## Department of Transportation

RE: Grandview Reserve Sketch Plan - EA2020

- CDOT Hydraulics Engineer has reviewed the Master Development Drainage Plan dated August 2020 by HR Green Development, LLC. and their comments are as follows:

NOTES:

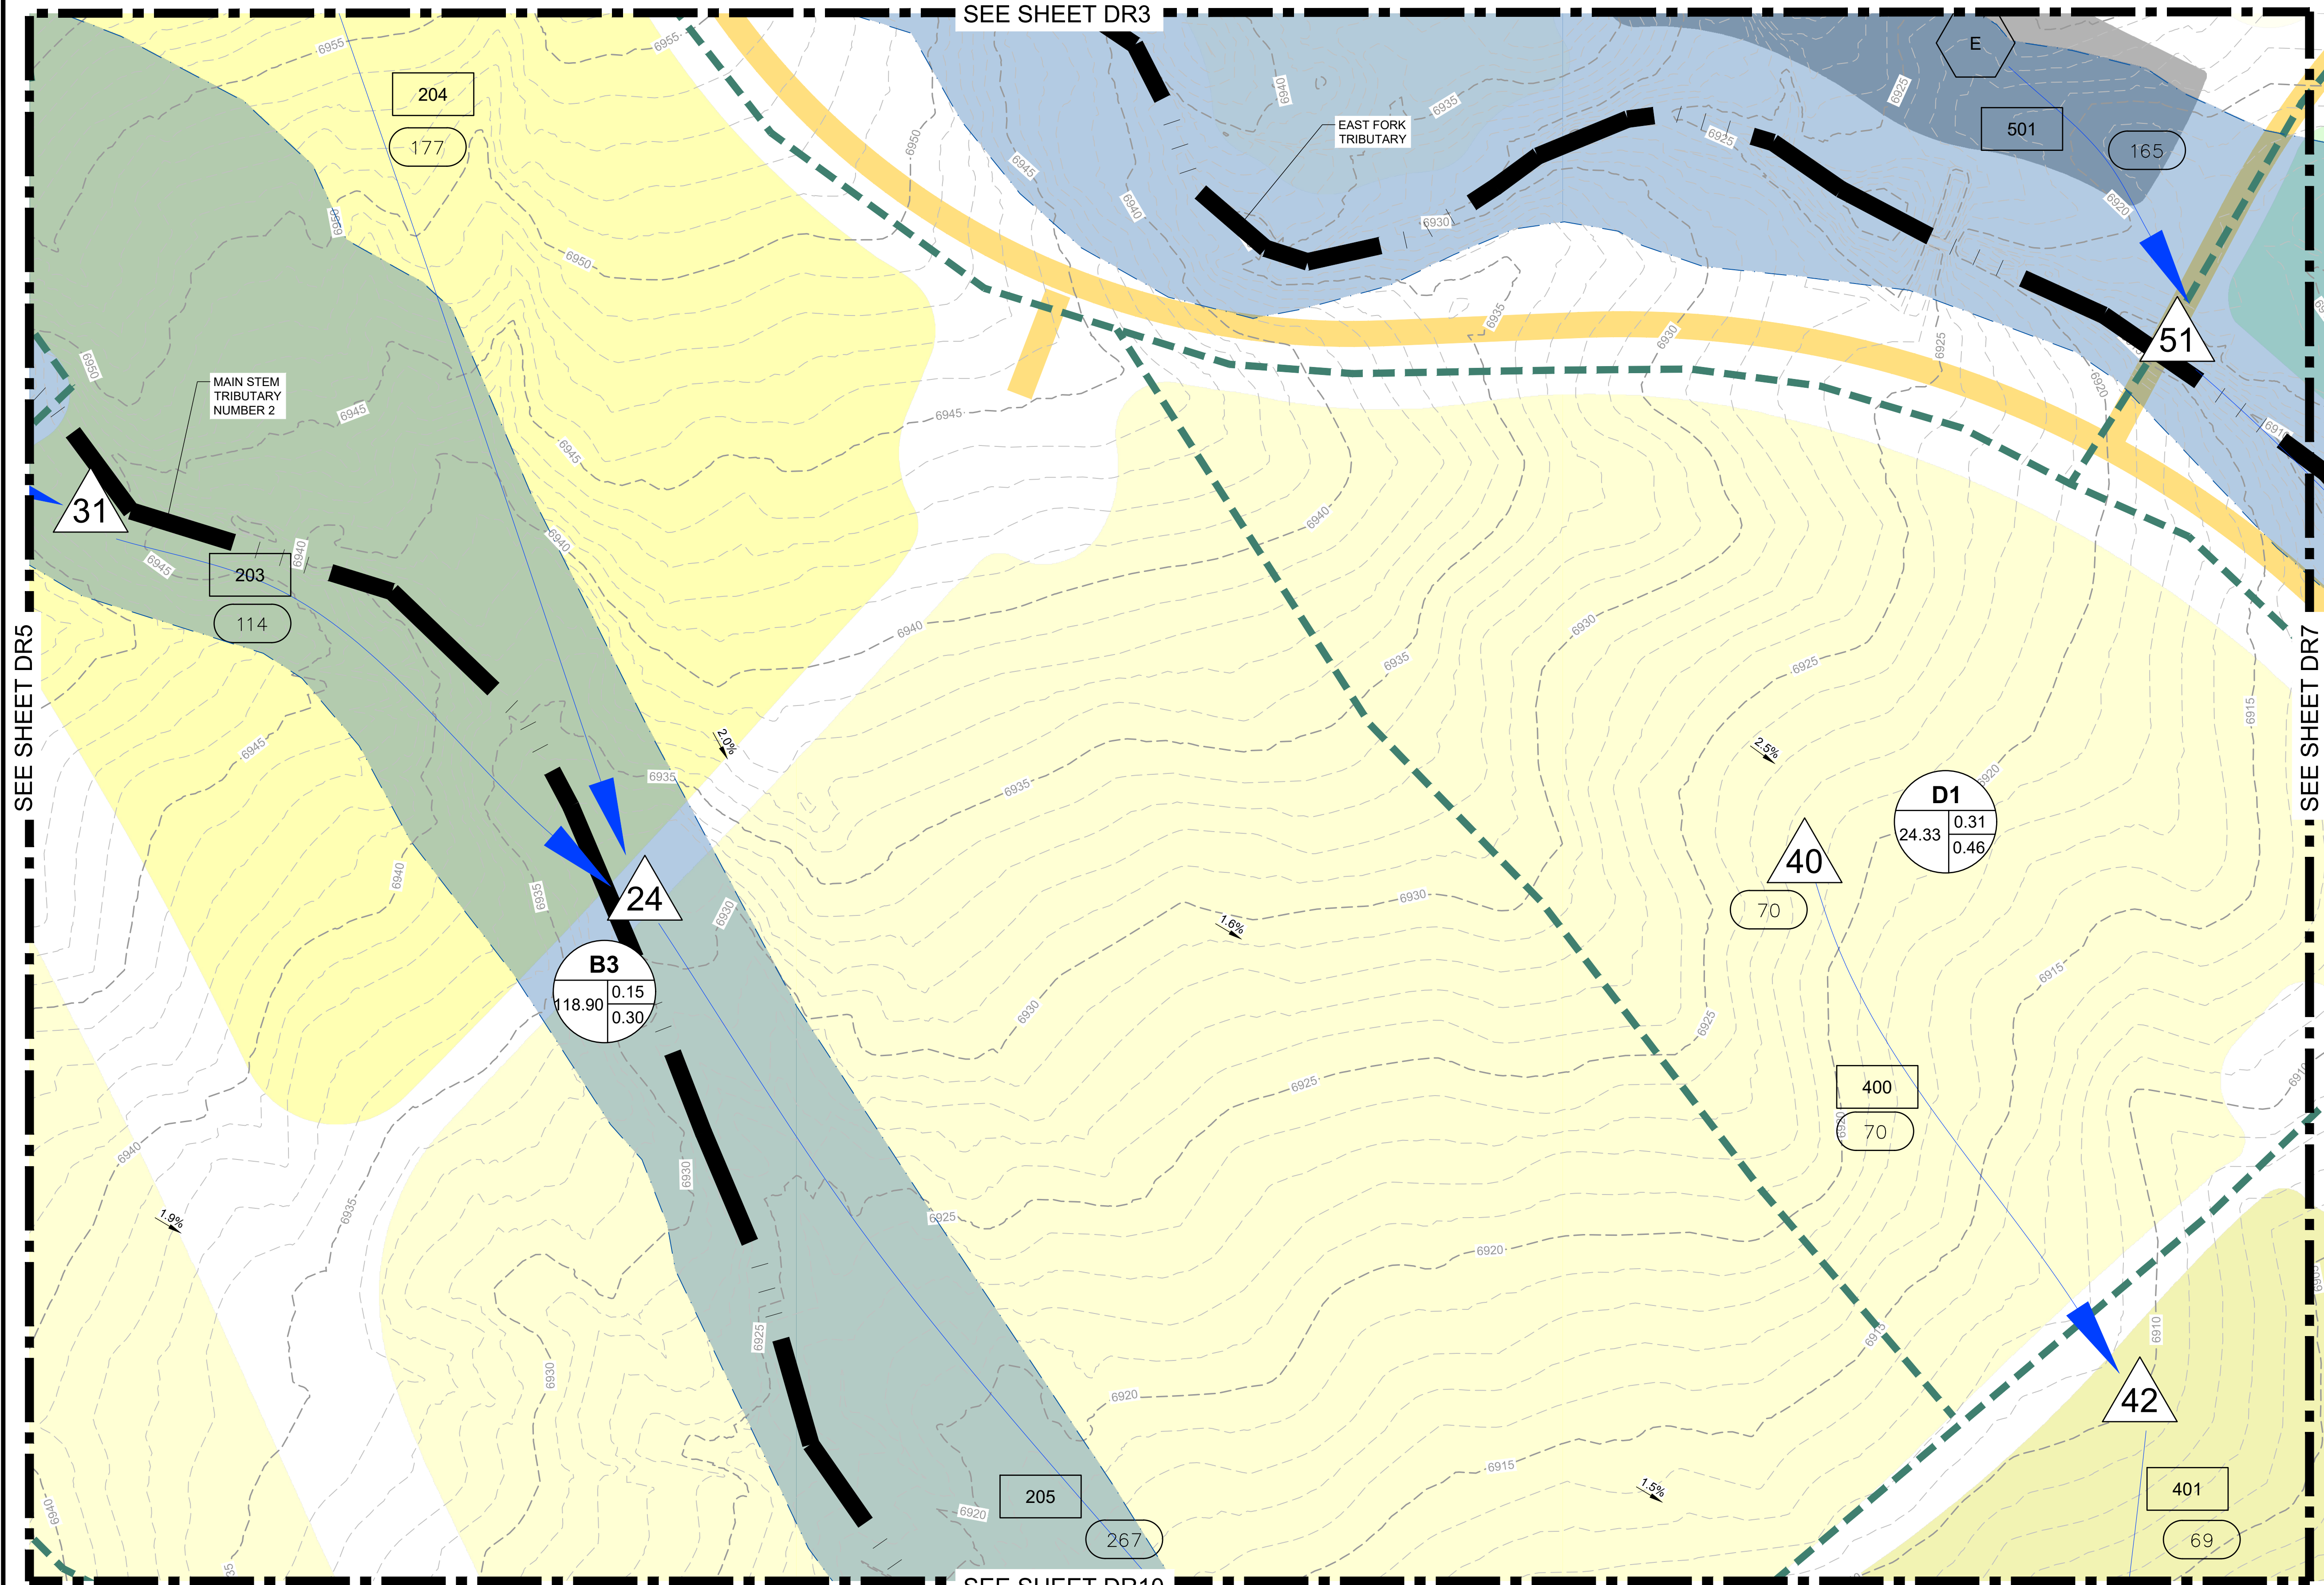
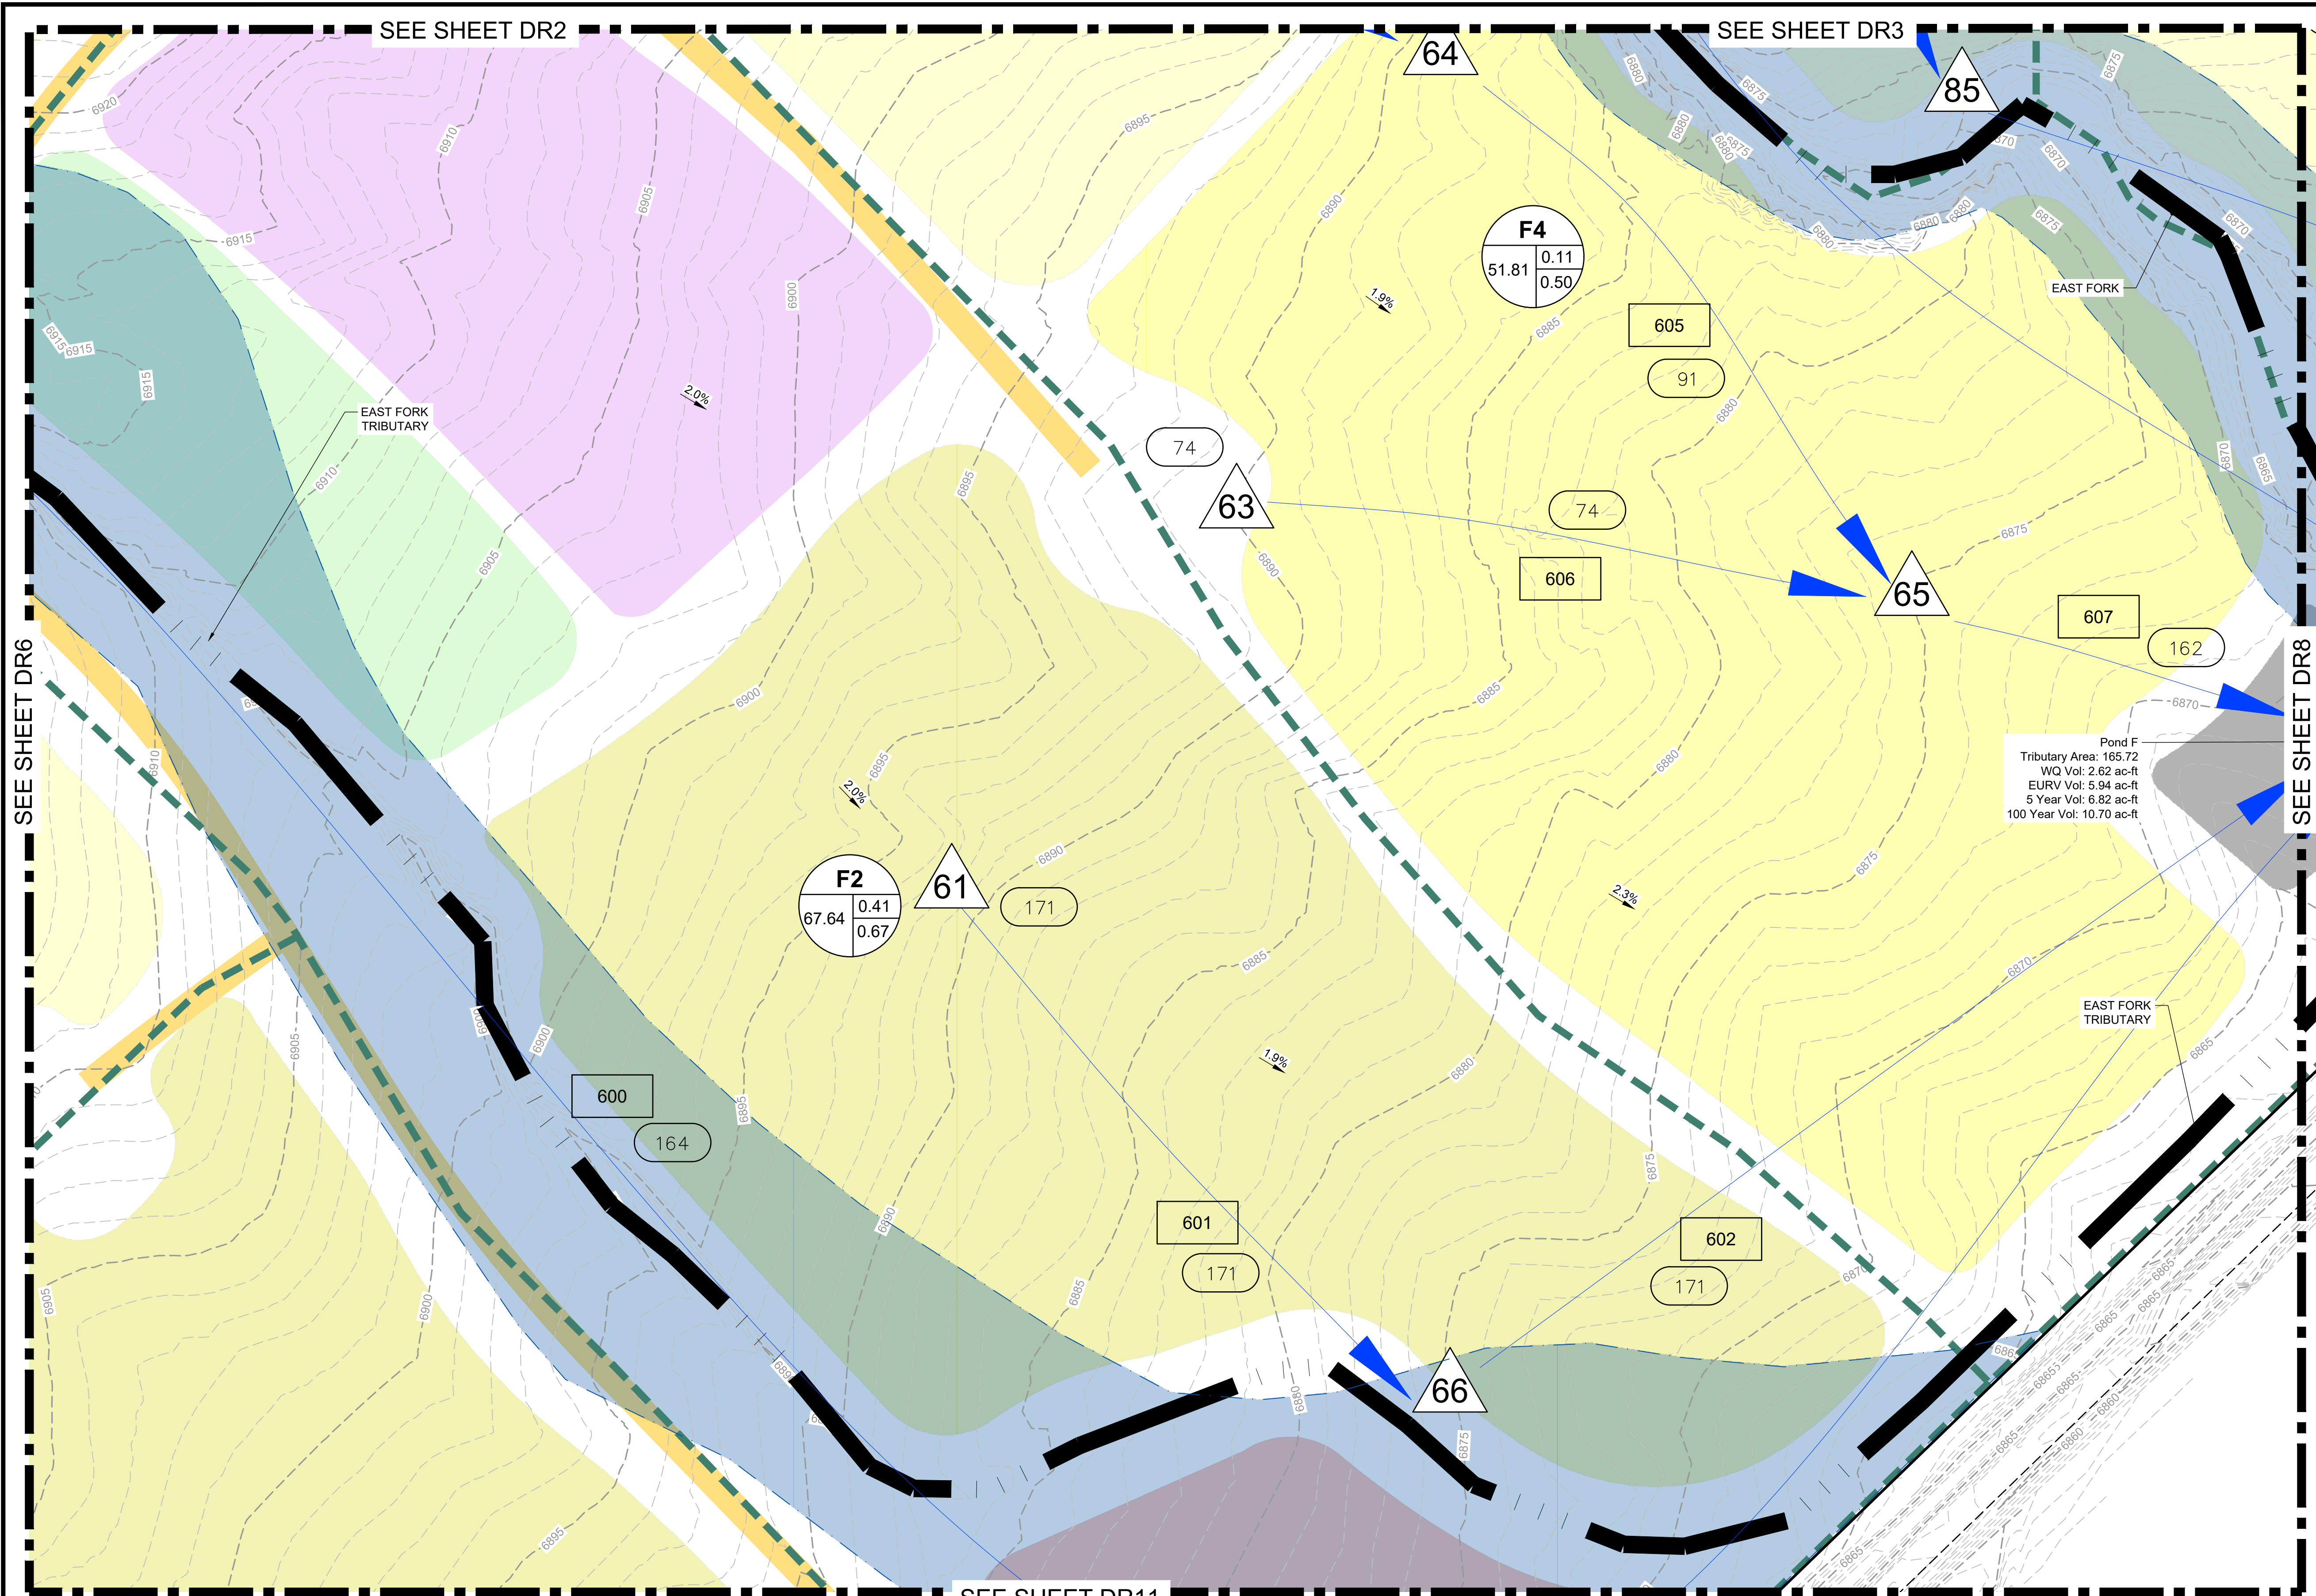
- c) Revise land use legend to accurately reflect the colors in the maps.
  - d) Almost all of the EDBs encroach in the floodplain. This will need FEMA approval (CLOMR/LOMR) along with the channel work.

- e) Given that this is an MDDP, more detail should be provided for the channel modifications to better understand impacts. Provide a grading plan or at the very least a typical cross section of the proposed channel improvements, locations for proposed grade control structures, etc.
